From: Martyn White
Sent: 29 June 2018 13:44
To: Planning.Responses
Subject: BR/106/18/A

BR/106/18/A

PROPOSED ELEVATION

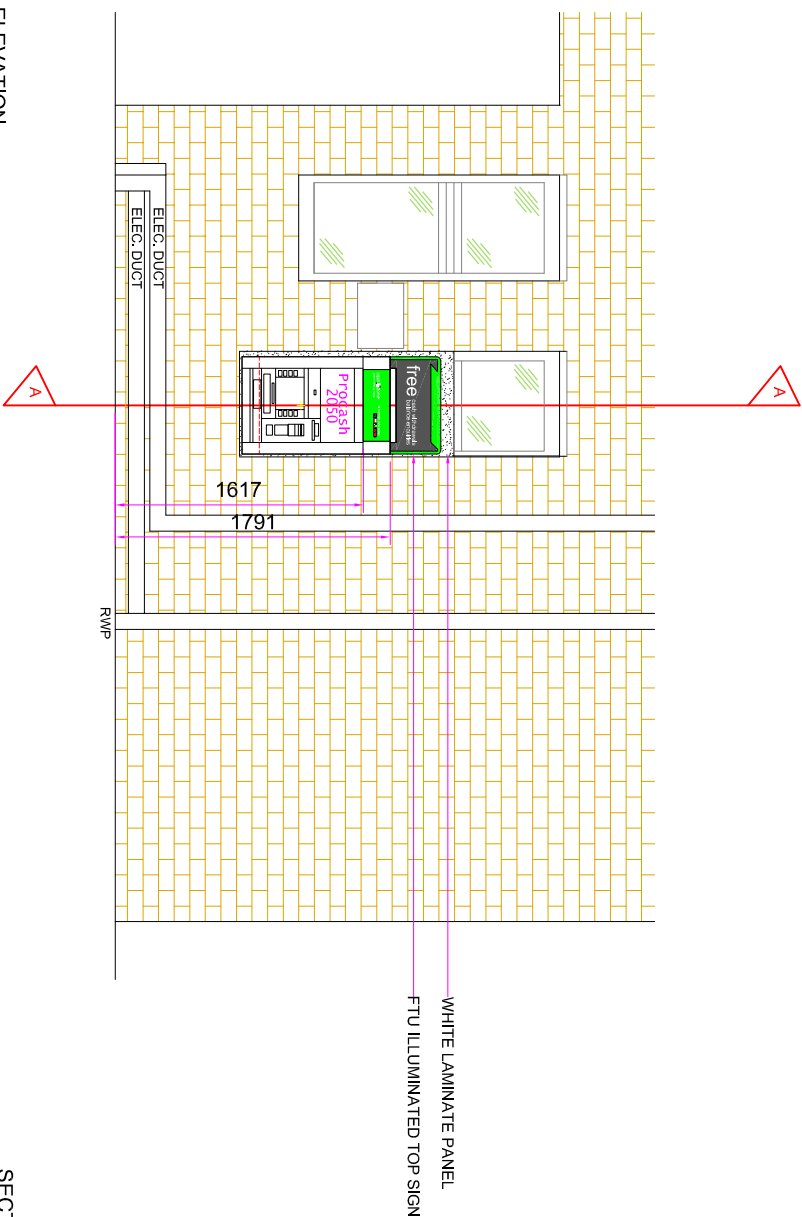
In line with the initial concept of the restoration/refurbishment works, it is considered that the amount of signage/lighting should be kept to a minimum. I note that the application is for one illuminated sign. This appears to be a fairly small sign that will have a neutral impact on the listed building, and the conservation area. It is also located within an area of other necessary infrastructure such as the network of cables, which reduces its impact.
